DECISION DELEGATED TO DEVELOPMENT MANAGER

Application No:	H23-0953-20	Applicant:	Mr Steve Collins & Miss Louise Stupples
Proposal:	Demolition of existing dwelling and construction of new dwelling.		
Location:	53 Broadgate Whaplode Drove Spalding		
Terminal Date:	17th January 2021

Proposed Ground Floor Plan
Scale 1:50

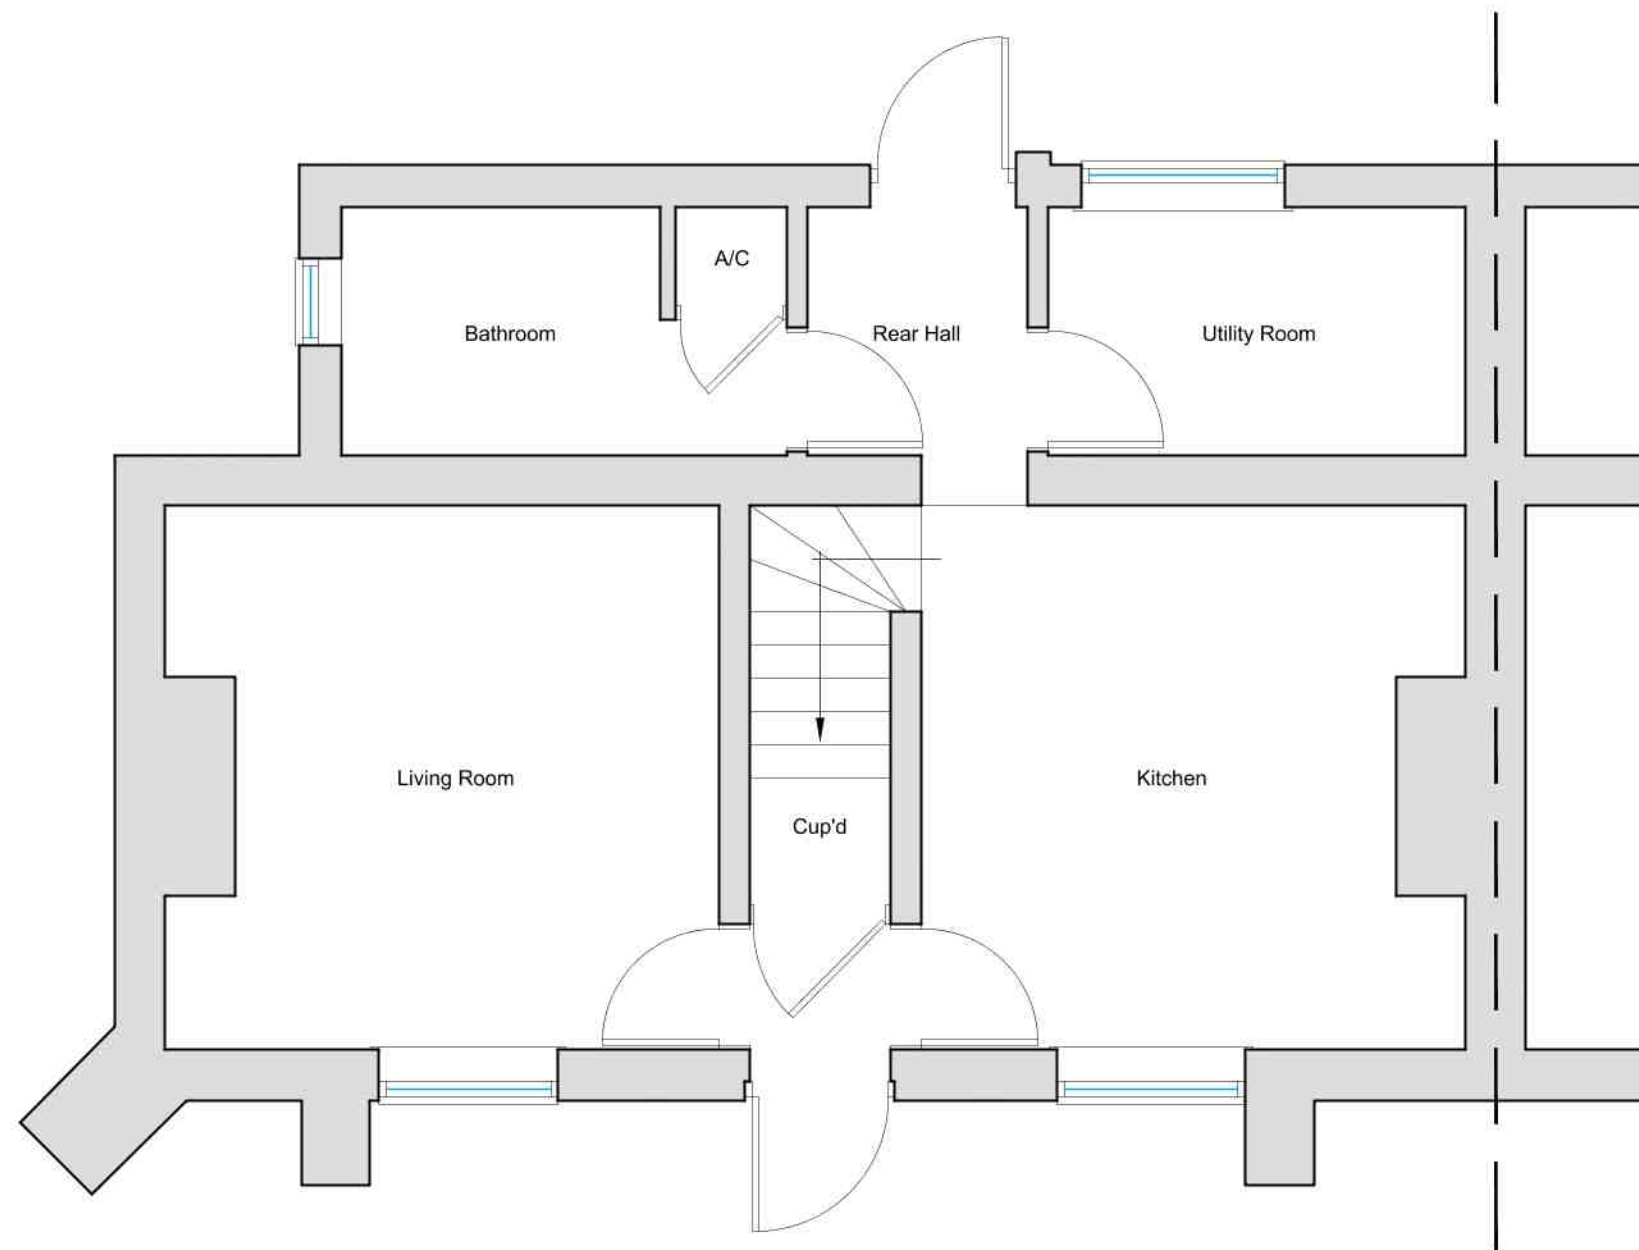
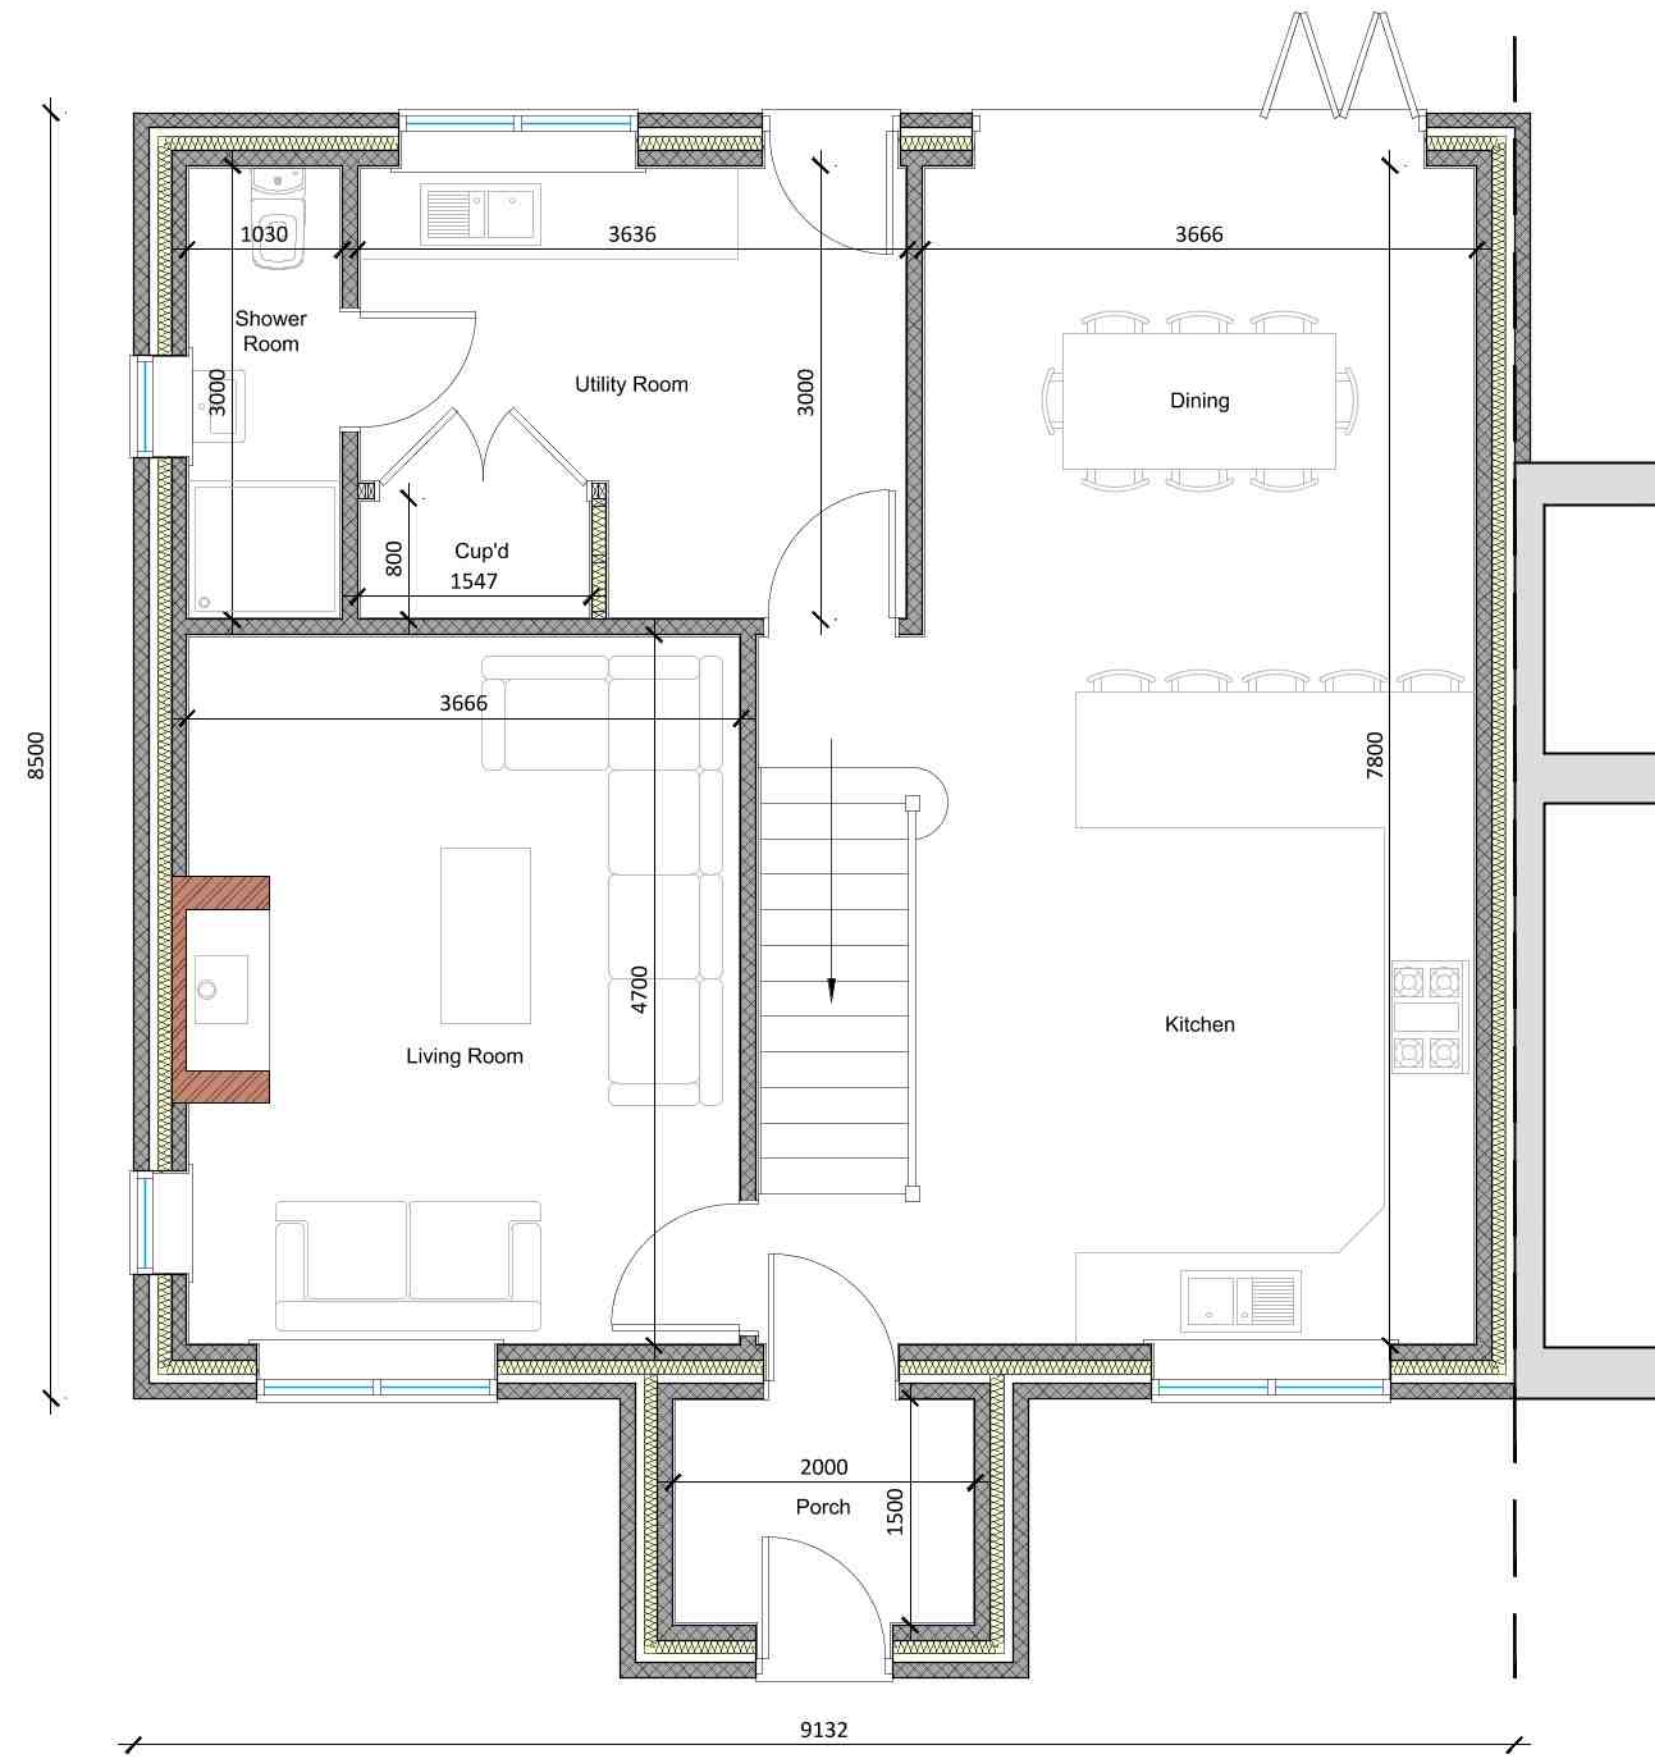
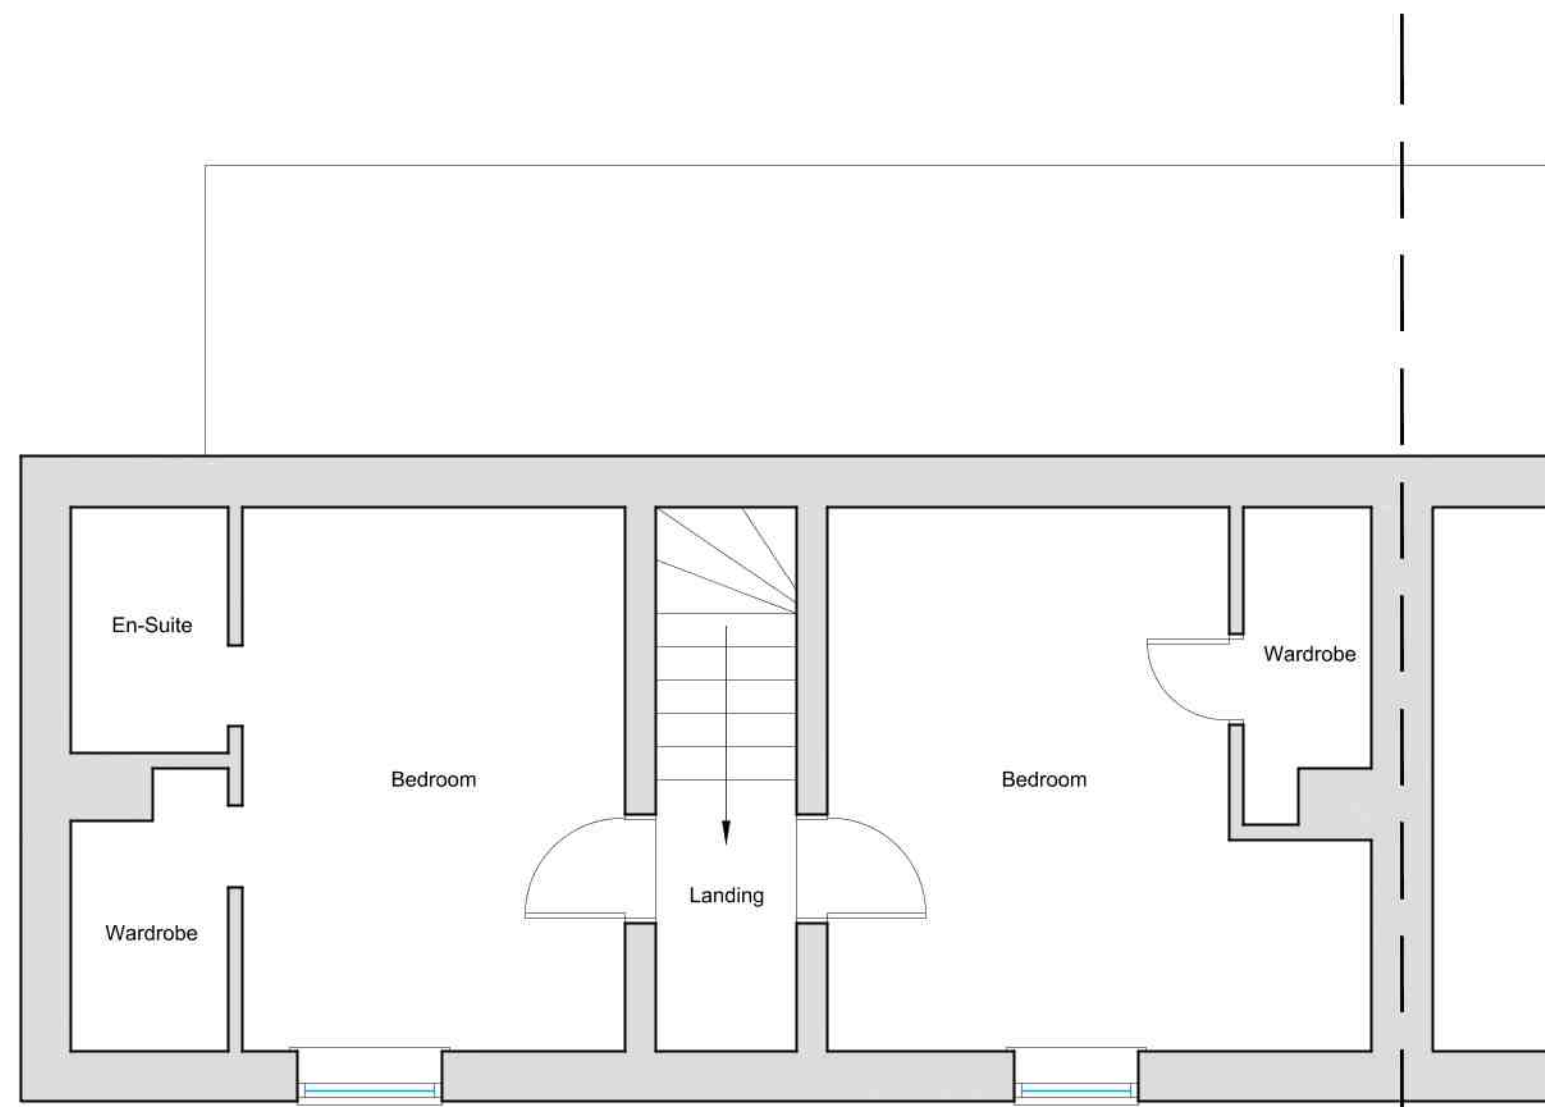
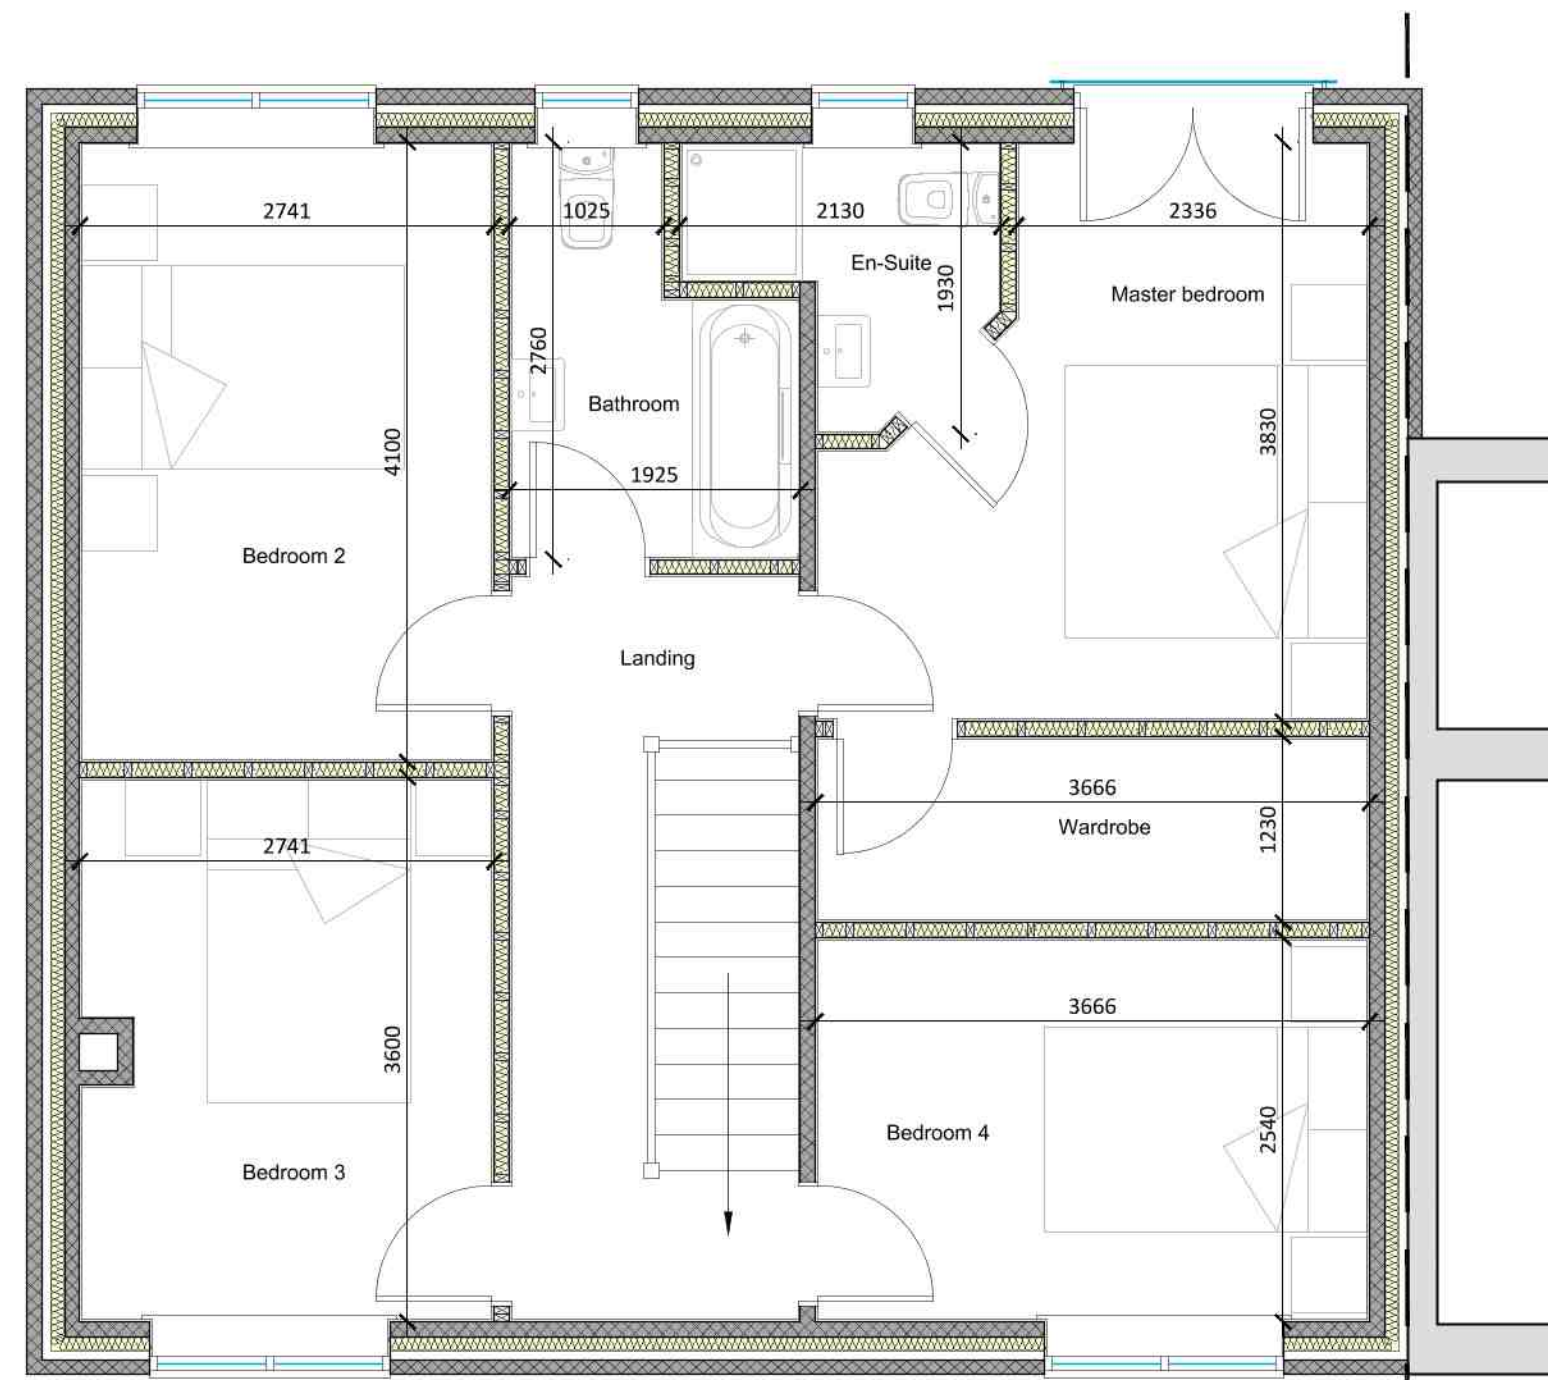
Internally, the communal space will be on the ground floor level. There will be a large open kitchen/dining room with bi-folded doors onto the garden. Four bedrooms will be provided on the first-floor level. One of them will be an ensuite master bedroom. The floorspace per each room will exceed the minimum standards for good standards of living. Nationally Described Space Standards (NDSS) have been used as a guidance to assess the proposals in this regard.

Proposed Front (W) Elevation
Scale 1:100

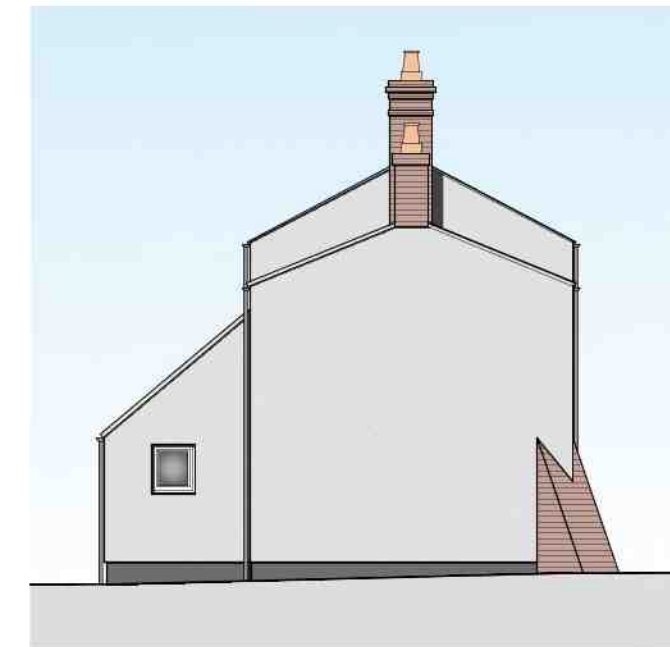
Having regard to the dimensions of the existing cottage, the proposed dwellinghouse will exceed 2.3 metres in depth and 80 centimetres in apex height. The width will be identical. The ridge height will be as much as that of the adjoining semi-detached cottage (No. 53b). For these reasons, the development will be commensurate with the adjoining property and other buildings in its setting in terms of scale, mass and bulk.

The proposed roof will be tantamount to the gable pitched roof of No. 53b. Two subservient gable pitched elements will project onto the rear of the plot. Both protrusions will fill the additional depth to the house. The front wall will be positioned as originally. A small-scale gable pitched porch will be erected at the main door.

The external walls will be white rendered. The roof tiles will be brown concrete matching those of the adjoining cottage. A new chimney would be erected on top of the gable pitch in addition to a shared stack on the other end of the roof. White UPVC will be used for doors and windows excepting the oak feature on the main door.

Proposed Rear (E) Elevation
Scale 1:100

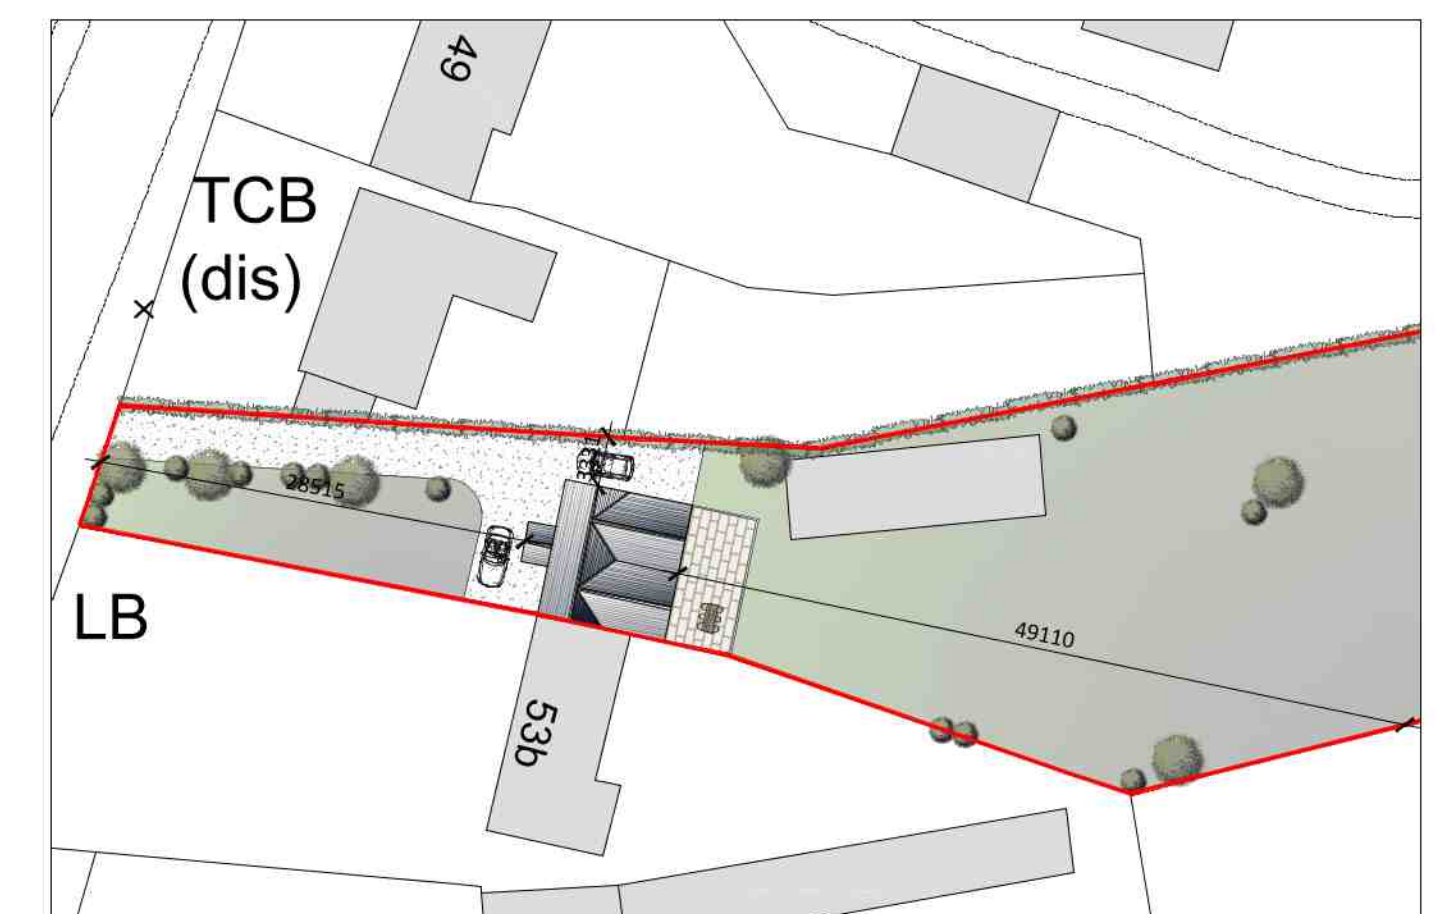
The two gable pitched elements at the rear of the house will represent an increase of 2.3 metres in relation to the footprint of the existing cottage.

There are two first-floor windows on the rear elevation of the adjoining property No. 53b. The rear elements will not protrude to the extent which the sightline from those windows will be obstructed. The 45 degrees angle will be clearly respected. In any case, the nearest window is a narrow opening which is unlikely to lighten a habitable space of the house.

The master bedroom adjoining the southern wall of the house will benefit from a Juliette balcony. As there is no protruding platform, it is considered that no overlooking effect will occur onto the rear garden of No. 53b.
